Response to Planning application from Hertfordshire County Council (T and CP GDP Order 2015)

District ref: 6/2021/2816/HOUSE
HCC ref: WH/10006/2021
HCC received: 20 December 2021
Area manager: Matthew Armstrong
Case officer: Paul Marshall

53 HIGH ROAD HATFIELD AL9 6HS

AMENDED PROPOSAL
Extension of existing dropped curb

PROPOSED PLAN WITH EXTENDED
DROPPED KERB & BUSH REMOVAL

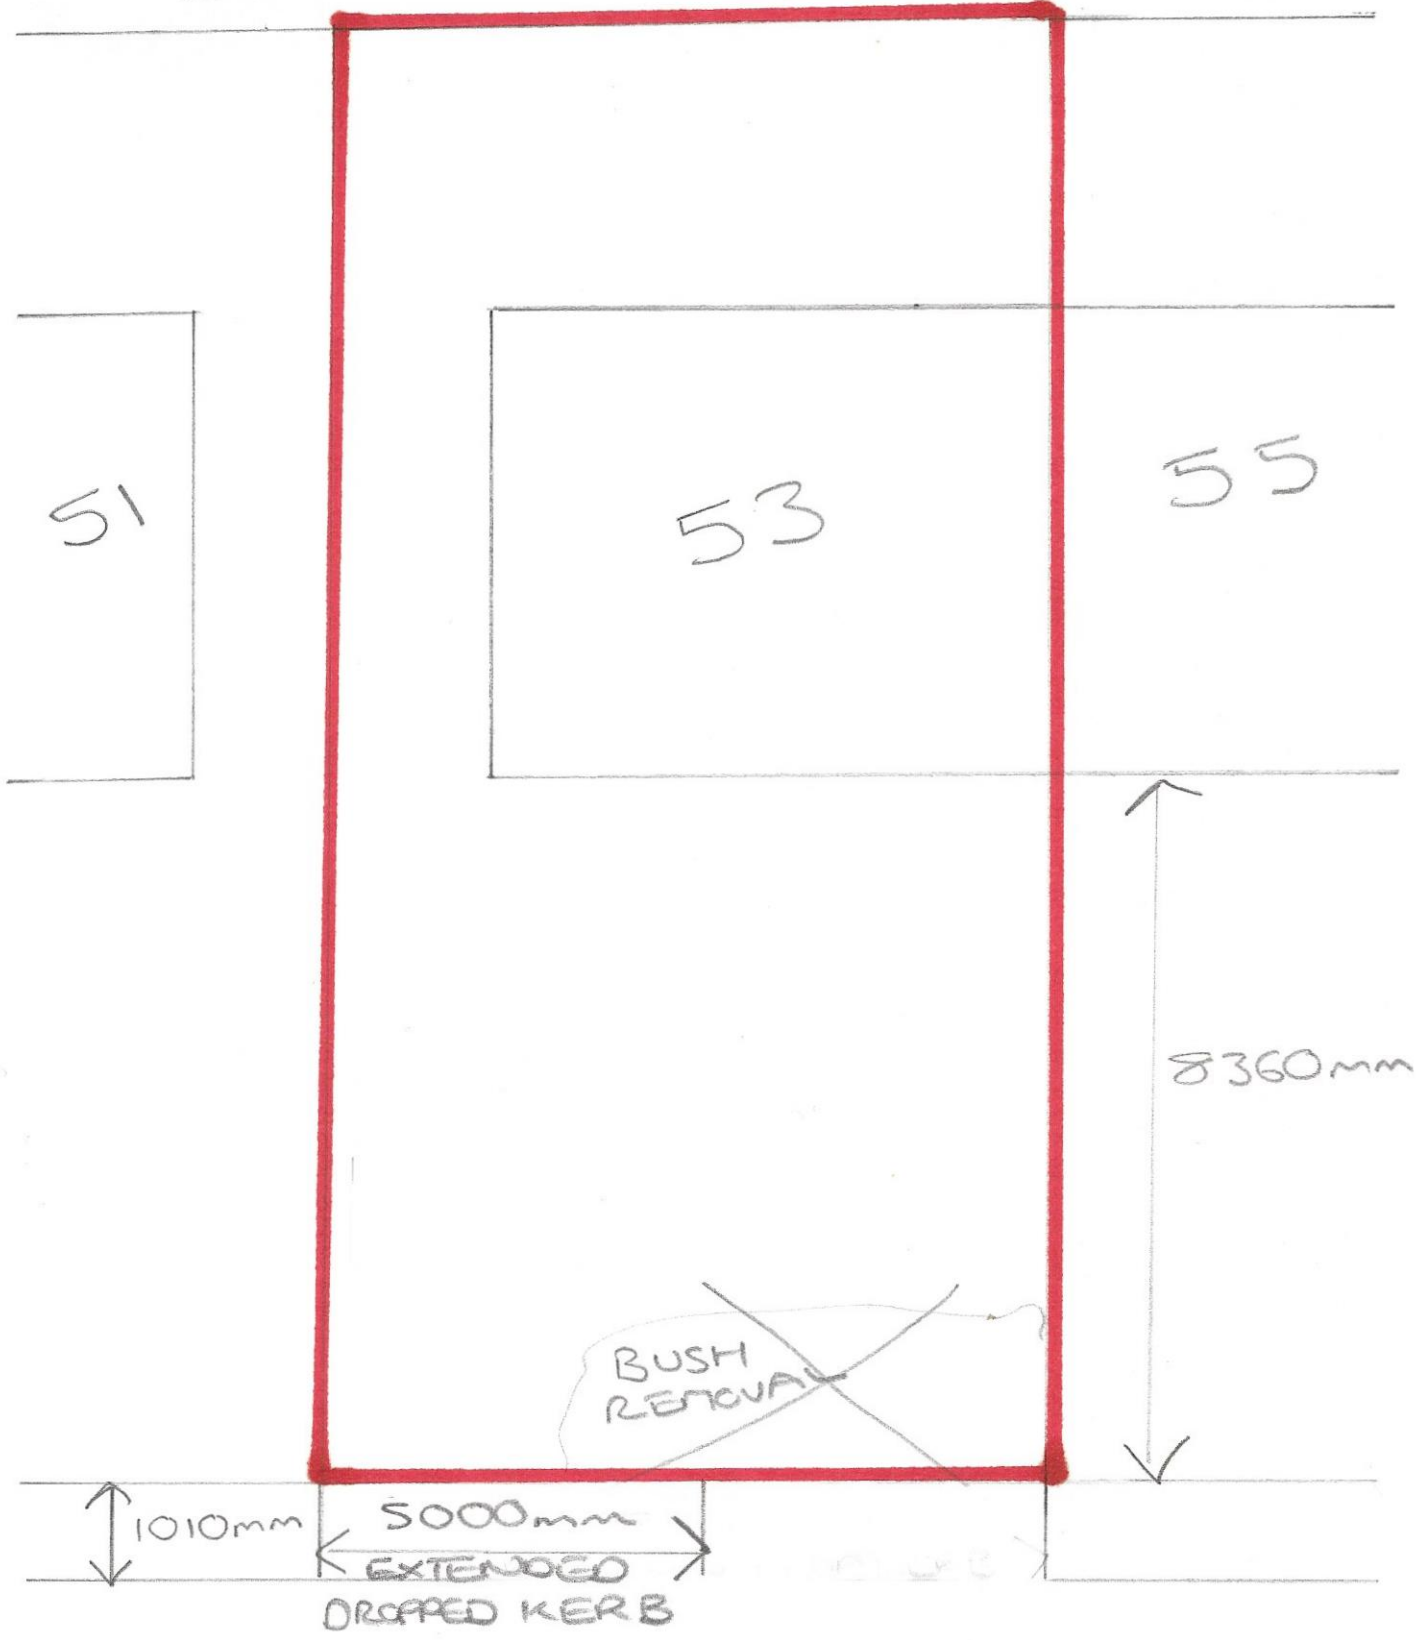
It is proposed to extend the existing dropped kerb by 3.6m creating an access of 5.4m maximum which is in line with HCC's Residential Dropped Kerb Terms and Conditions

The location and vehicular to vehicular visibility from the existing access is considered to be acceptable and in accordance with 'Manual for Streets (MfS)' and 'Roads in Hertfordshire: A Design Guide'
